SUBJECT: Uptown Project - NED's AND
OFFICE BUILDING

Re: Restaurant and Office Building
Uptown Boulevard
Planning Item Z-307-1
Preliminary Drainage Plan

RE: DRAINAGE PLAN FOR UPTOWN OFFICE BUILDING

DRAINAGE - GRADING PLAN

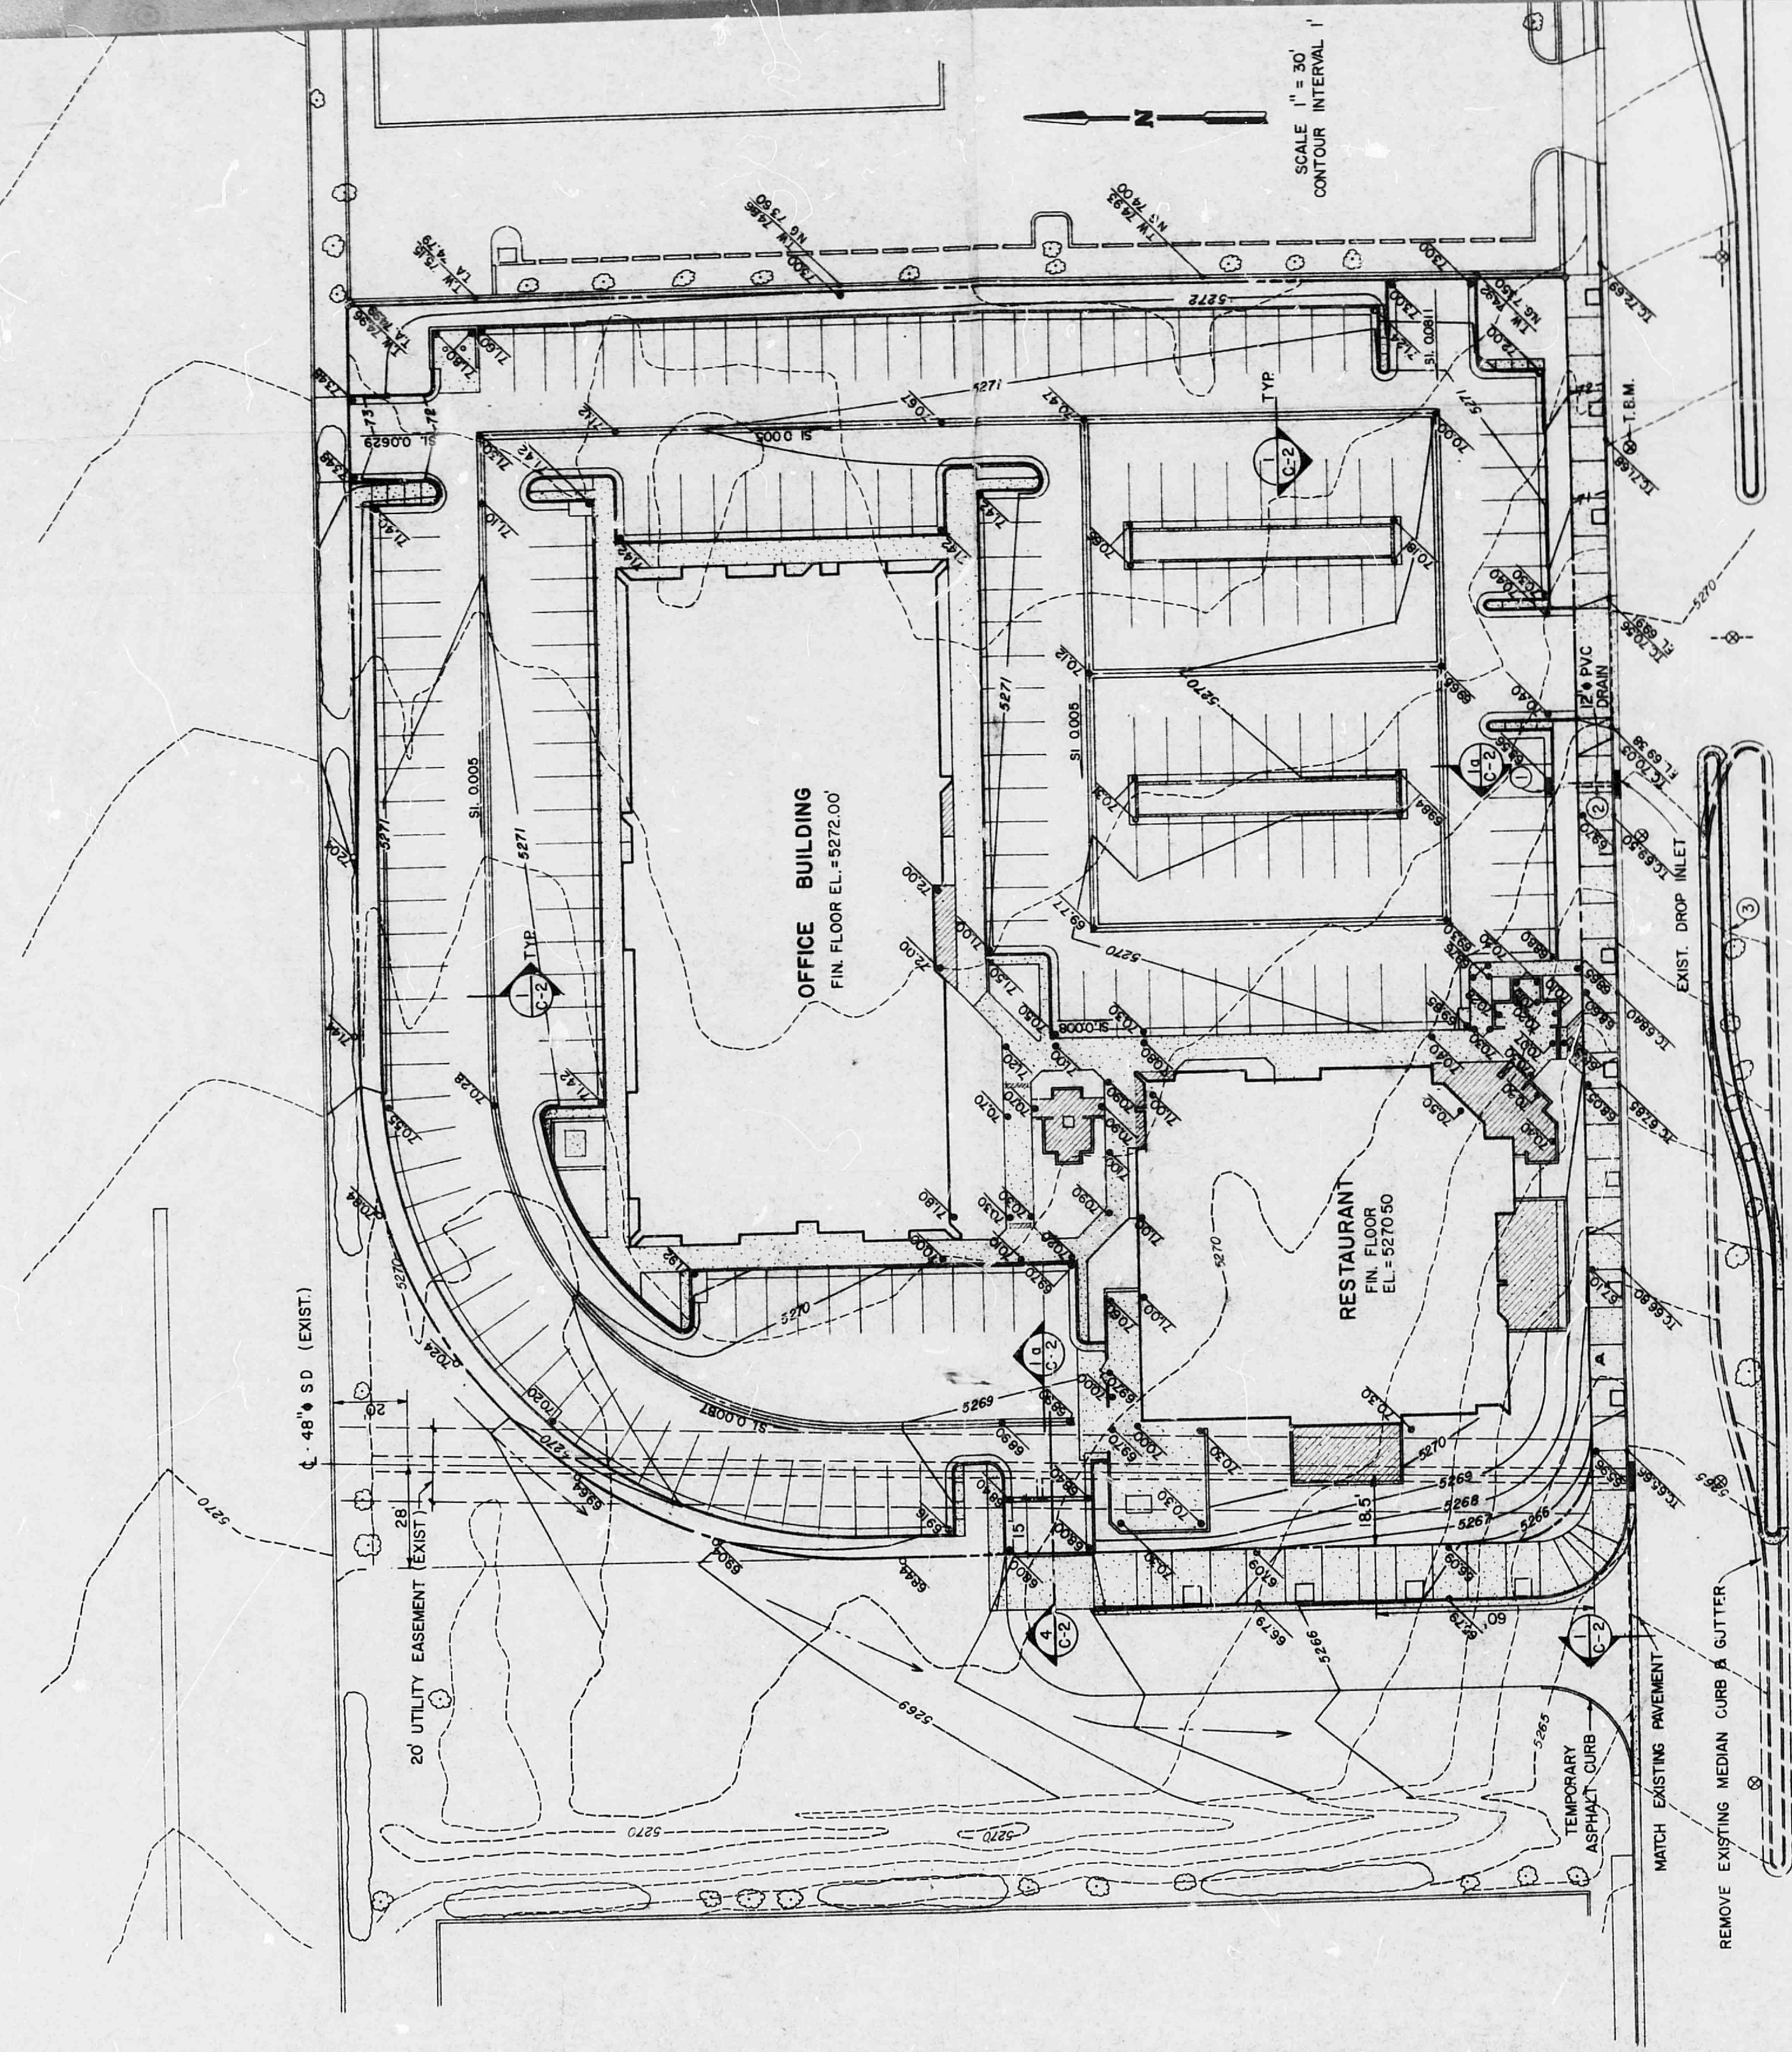
1. Approved copies of Special Order No. 19 should be placed in the City construction sets showing the storm sewer inlet and connection details.
2. In the future, please provide supporting capacity calculations for the storm sewer inlets and conveyance pipes.
3. This letter will serve as conceptual approval of the plan.
